Broadland District Council Response to Examining Authority's Written Questions (ExQ1)

Deadline 1 (6th July 2021)

ID	Length (m)	Width (m)	Depth (m)
SR1	132	10	3.1
SR2	100	10	4.5
SR3	120	10	3.8
SR4	40	7	4.2
SR5	70	10	3.7
SR6	30	7	3.7
SR7	75	10	4.4
SR8	52.5	7.5	3.4
SC1	15	7	2.7
SC2	100	10	3.4
SC3	100	10	2.8
SC4	100	10	4.5
SC5	100	10	2.5
SC6 (TBC)	100	10	4.5
SC7 (TBC)	75	10	4.5
SC8 (TBC)	175	10	4.5

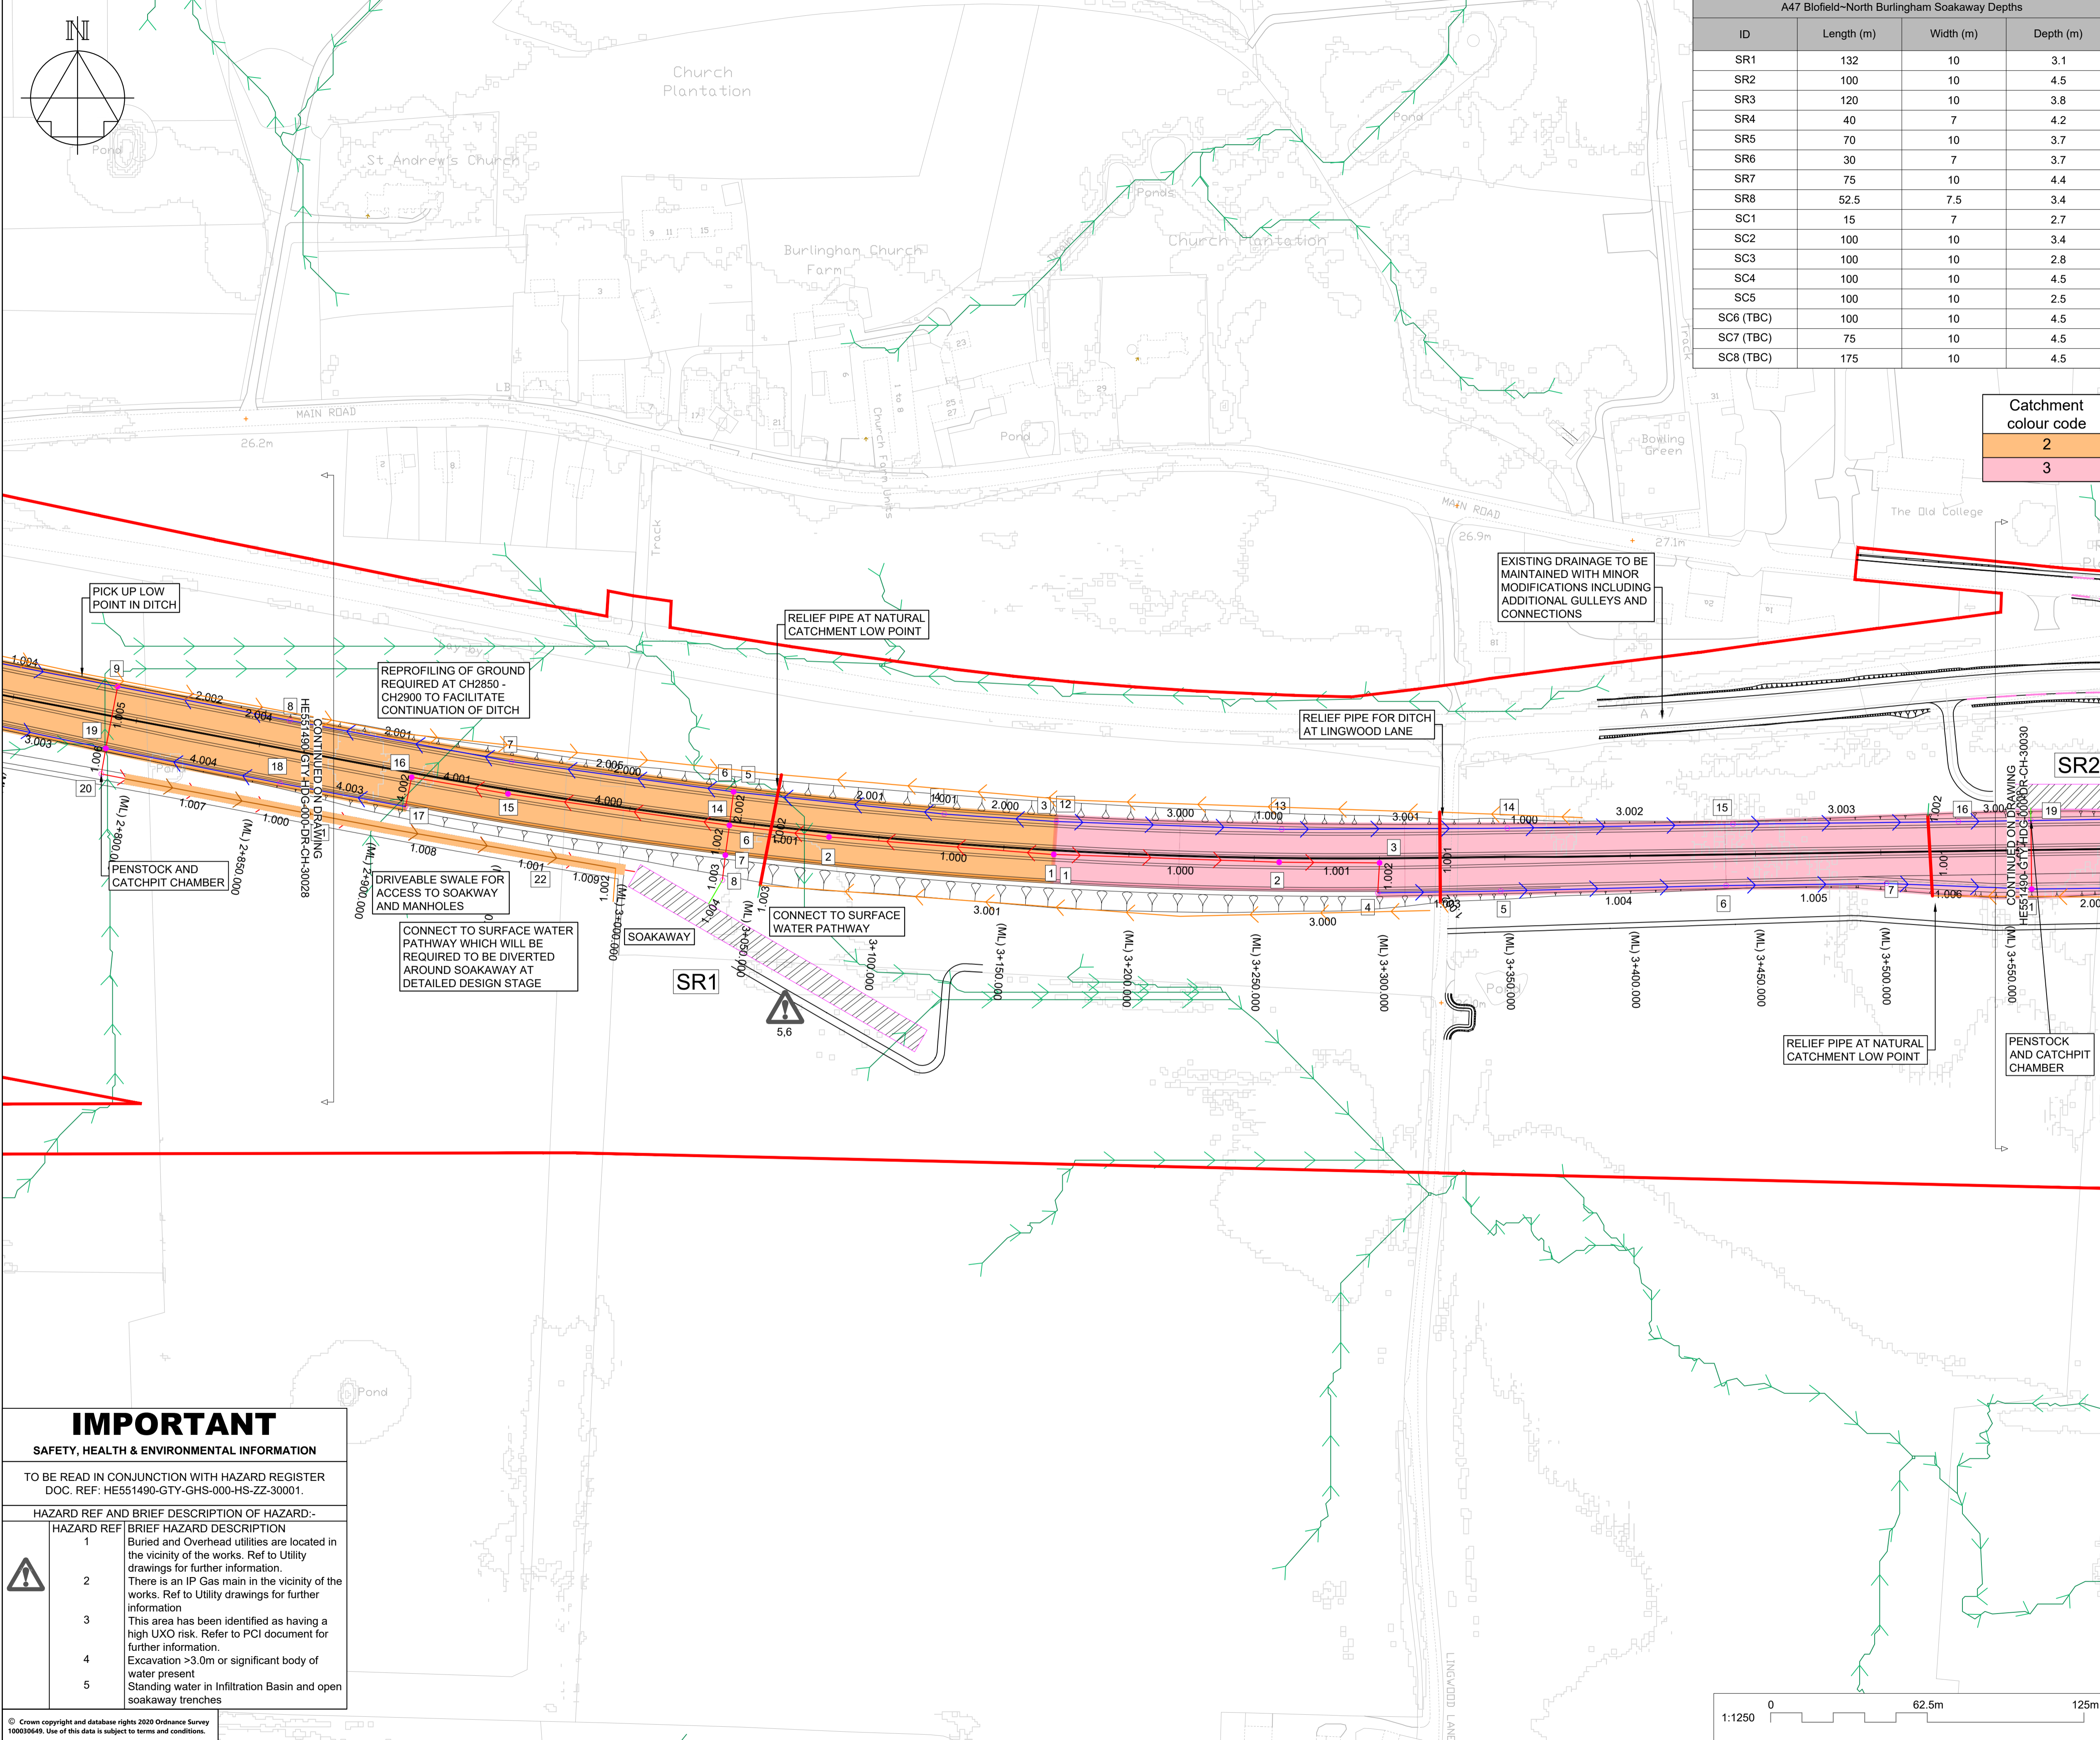
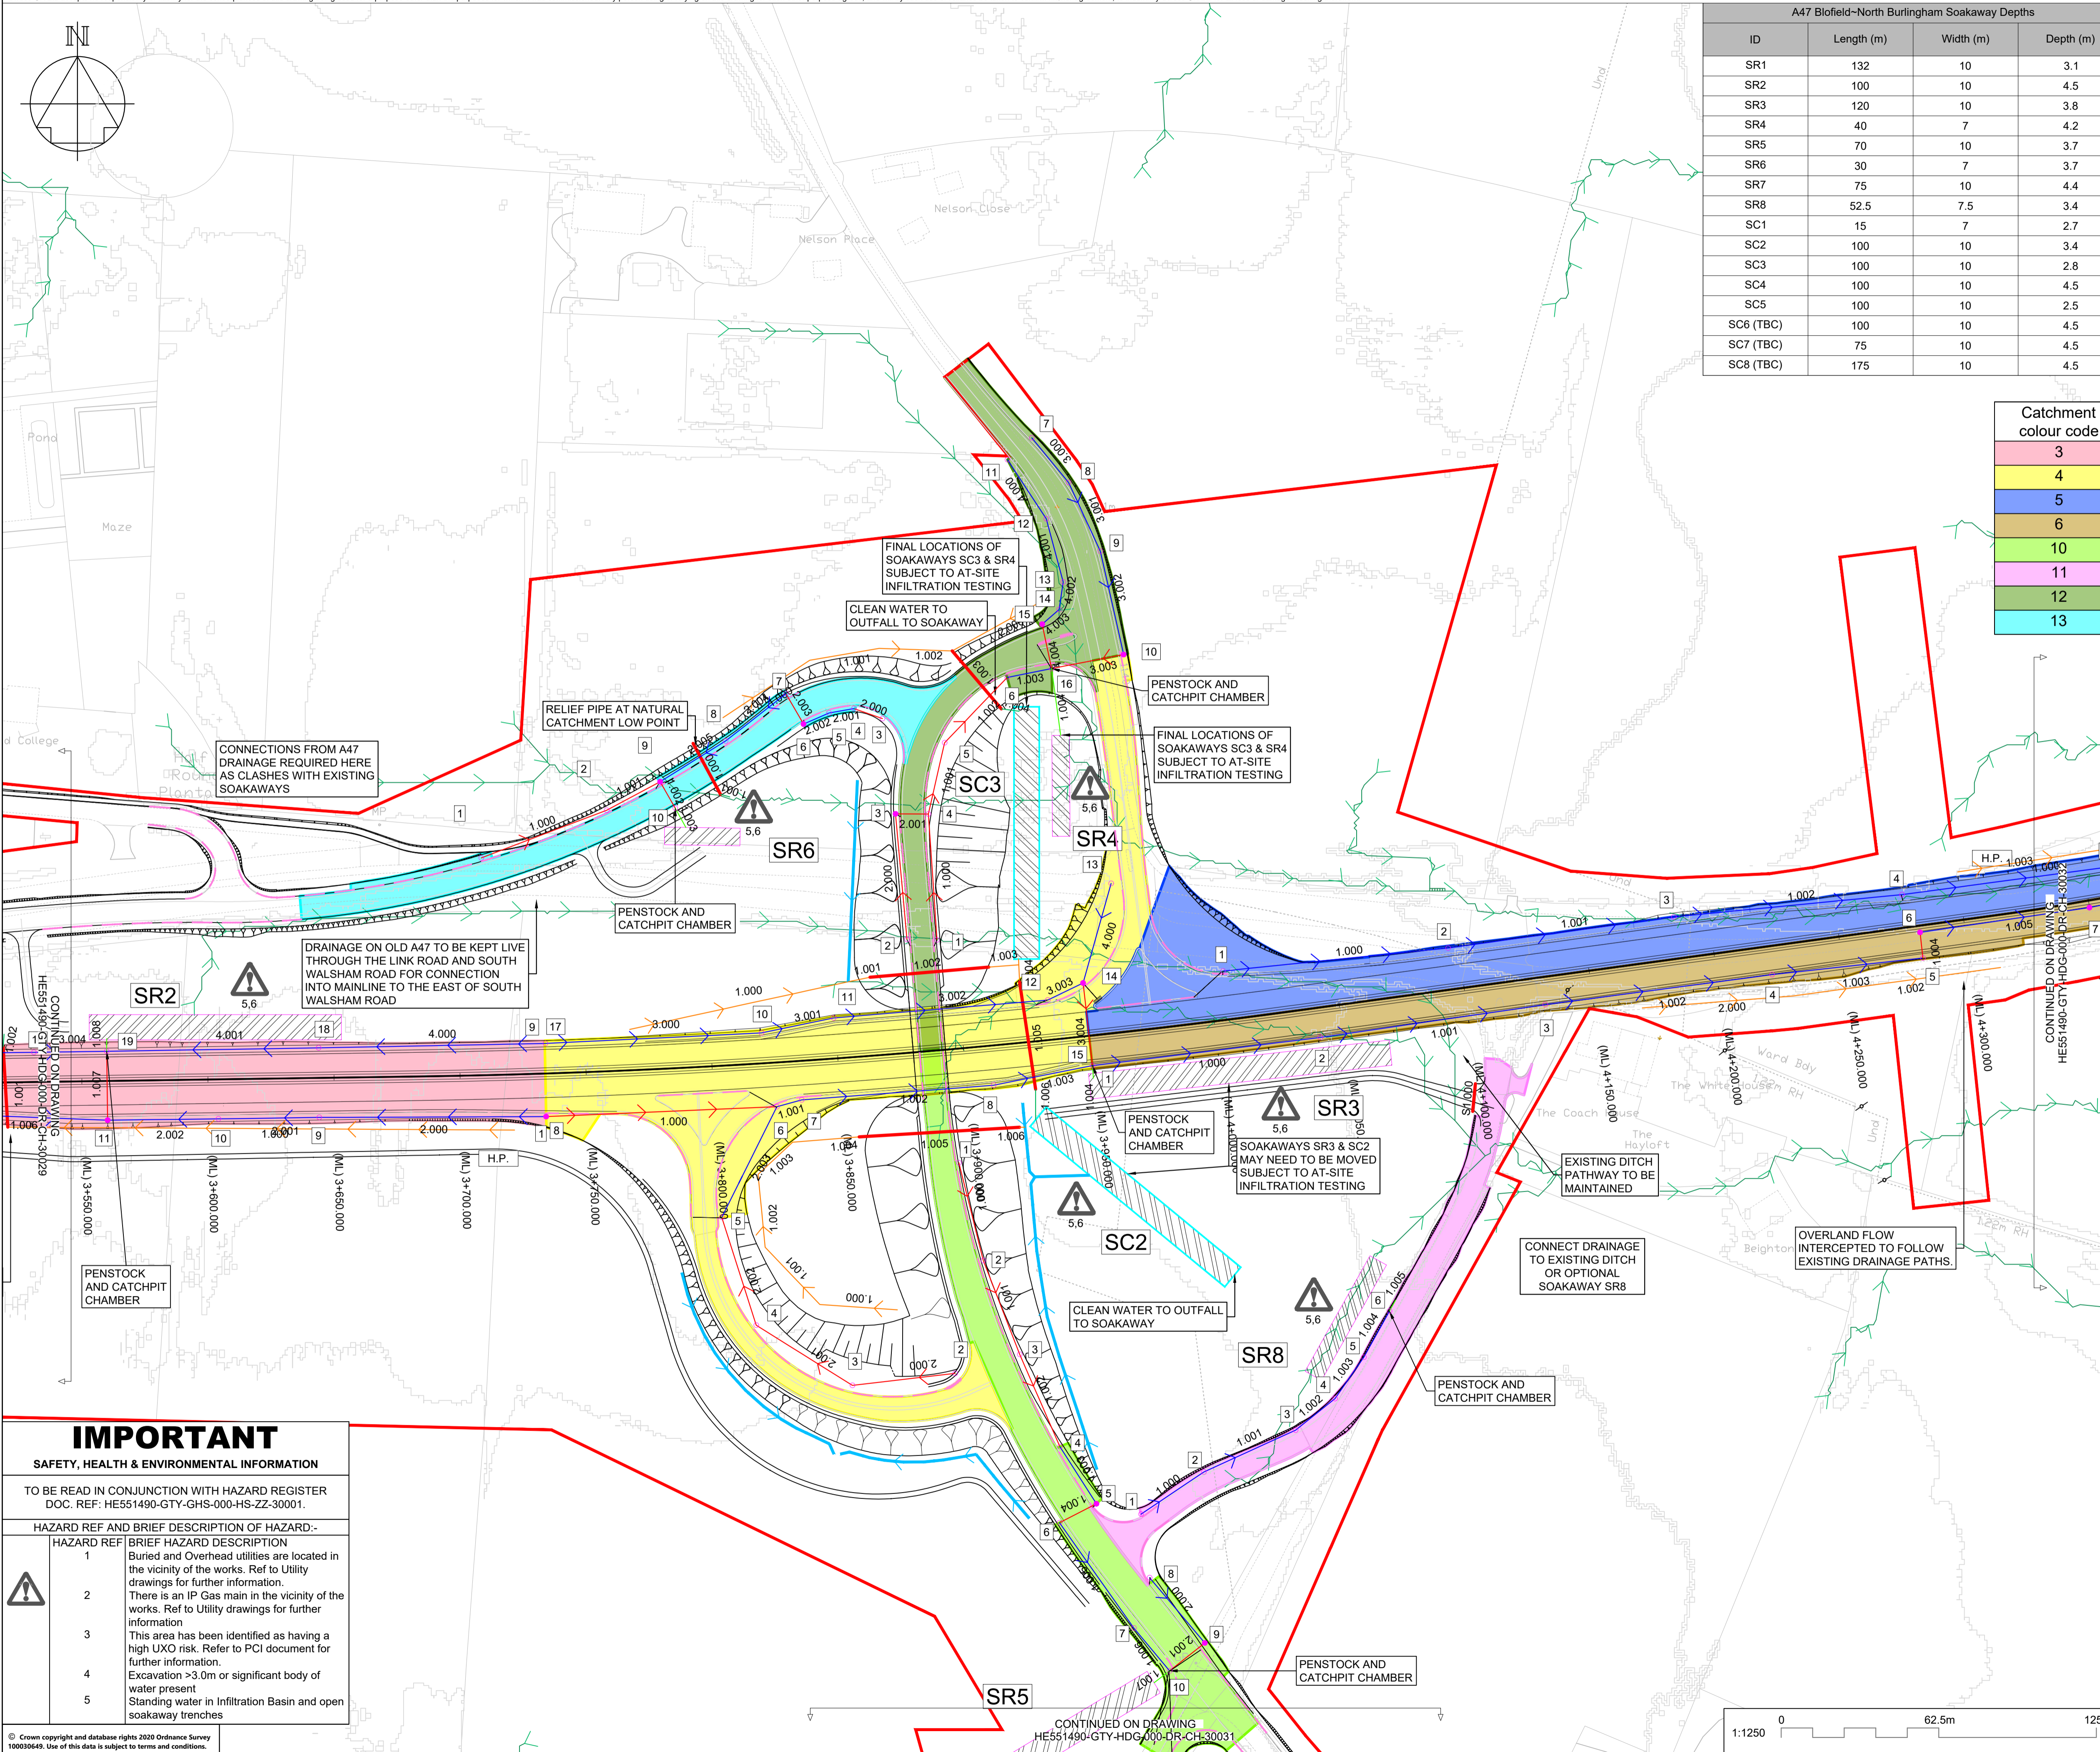
1.15.10	RR [RR-053] raises a concern around potential for increased flood risk to Waterlow Cottage as a result of the Proposed Development. Please provide a response to this concern.	We would endorse the comments from the resident and suggest that the applicant makes personal contact with Mr Trawford to explain the significant drainage proposals here including details of its design performance to hopefully demonstrate that it will operate satisfactorily without a positive outfall and not increase the water table and cause issues at the properties at Waterlow. The soakaway scheme does seem to be close to the eastern boundary of the houses.
